HILL SUBDIVISION FILING NO. 1

A REPLAT OF LOT 1, C AND H ESTATES

September 8, 2023

Re: *Minor Plat Comments VR2313*
Project No. 61174

HILL SUBDIVISION FILING NO. 1

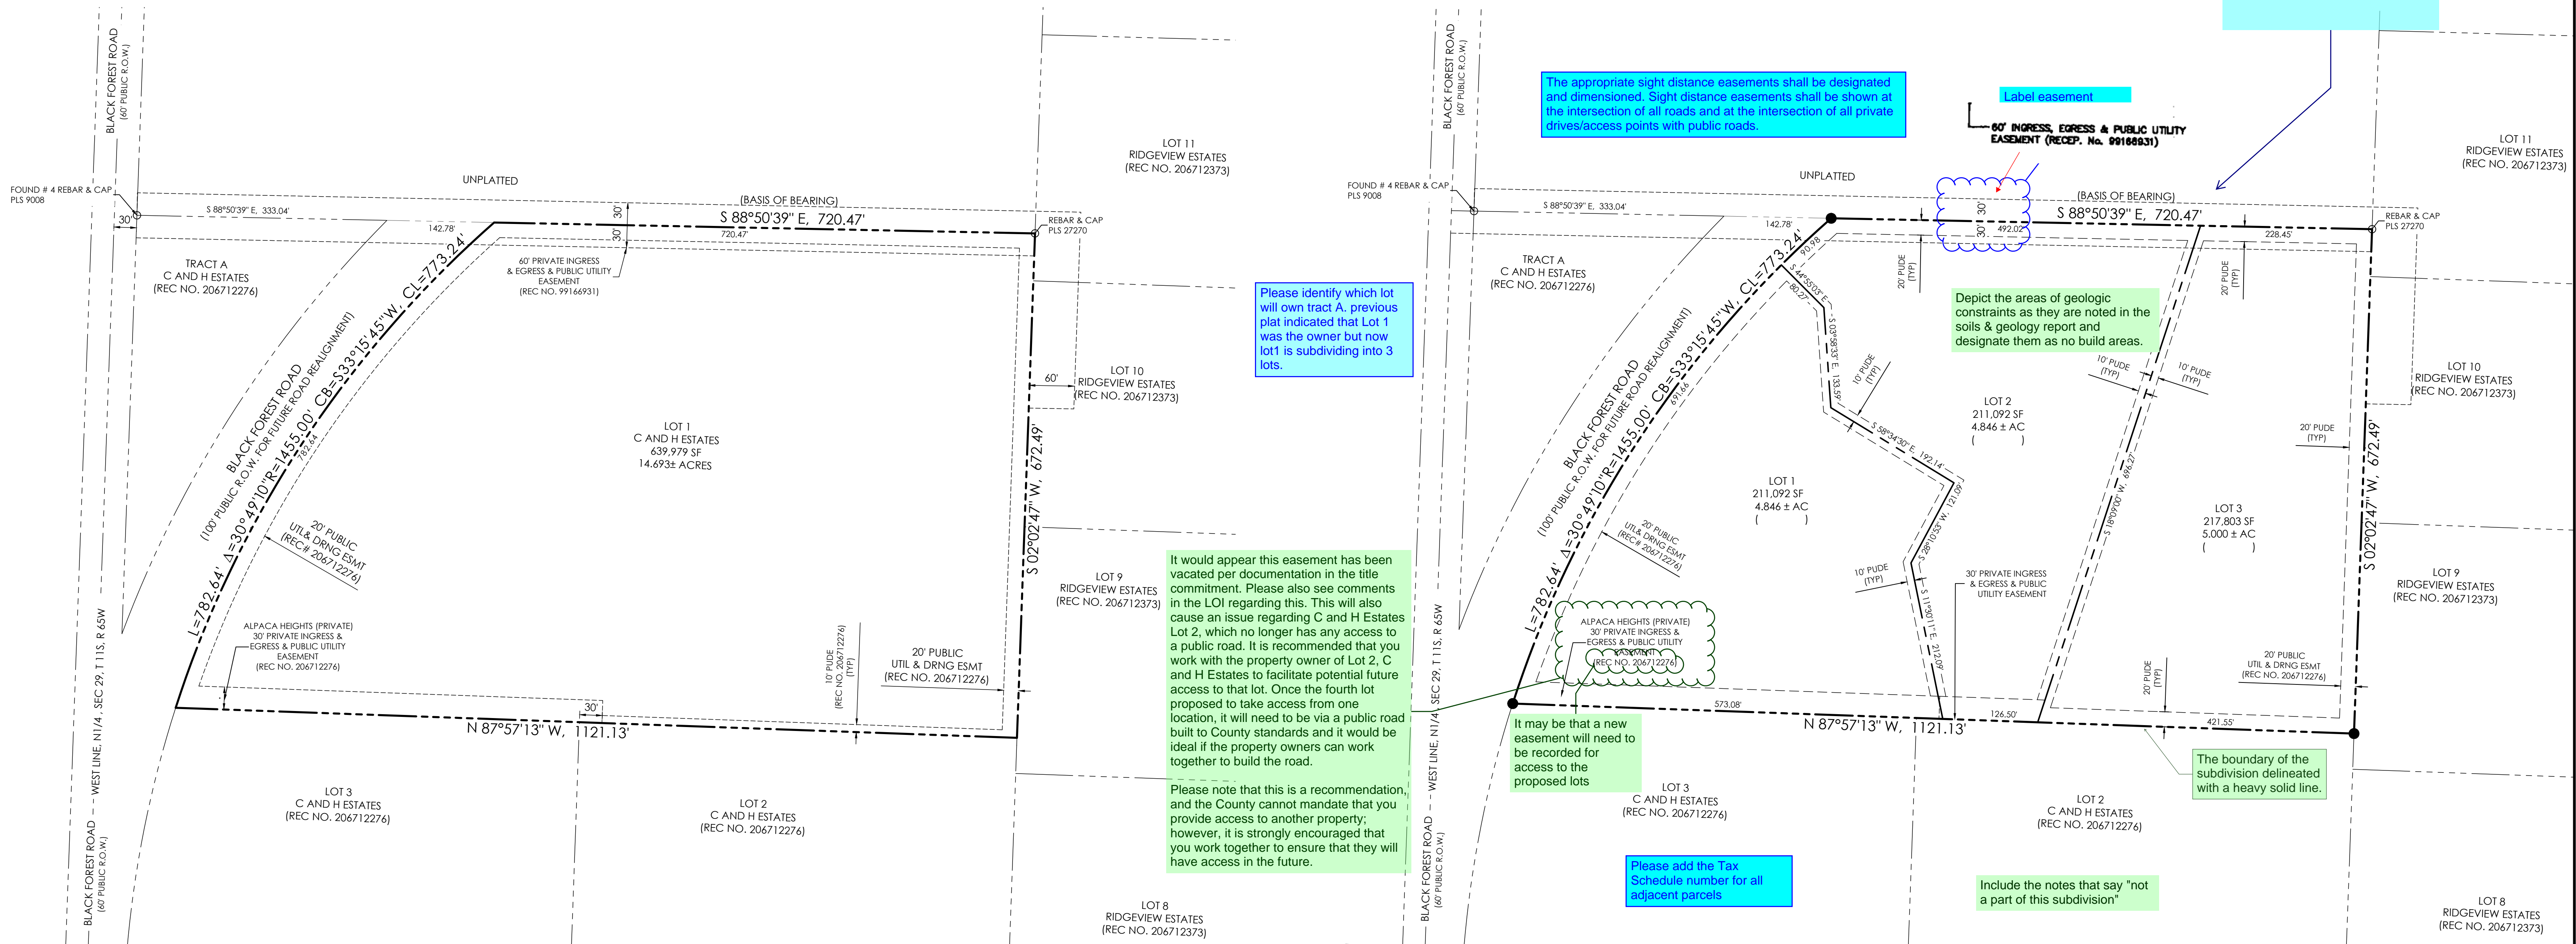
3. *“Depict the areas of geologic constraints as they are noted in the soils & geology report and designate them as no build areas.”*
The soils report outlines mitigation measures for all of the shown geologic hazards. No build areas should not be created for hazards that can be mediated through proper engineering design and construction practices.

5. *“Include the notes that say not a part of this subdivision”*
NAP (Not a Part of this Subdivision) was added to the legend and added to each surrounding property. Please note that the intention of the NAP note is to show areas WITHIN the boundary that are exempt and not a part of the subdivision. In this particular subdivision there are no areas

within the boundary that are not included. The very nature of a “Boundary” designates the area that is being platted and separates it from that remaining 2,130 square miles of El Paso County that is not being platted. To designate every parcel that is OUTSIDE of the boundary as not a part is redundant and does not coincide with the intent of the note.
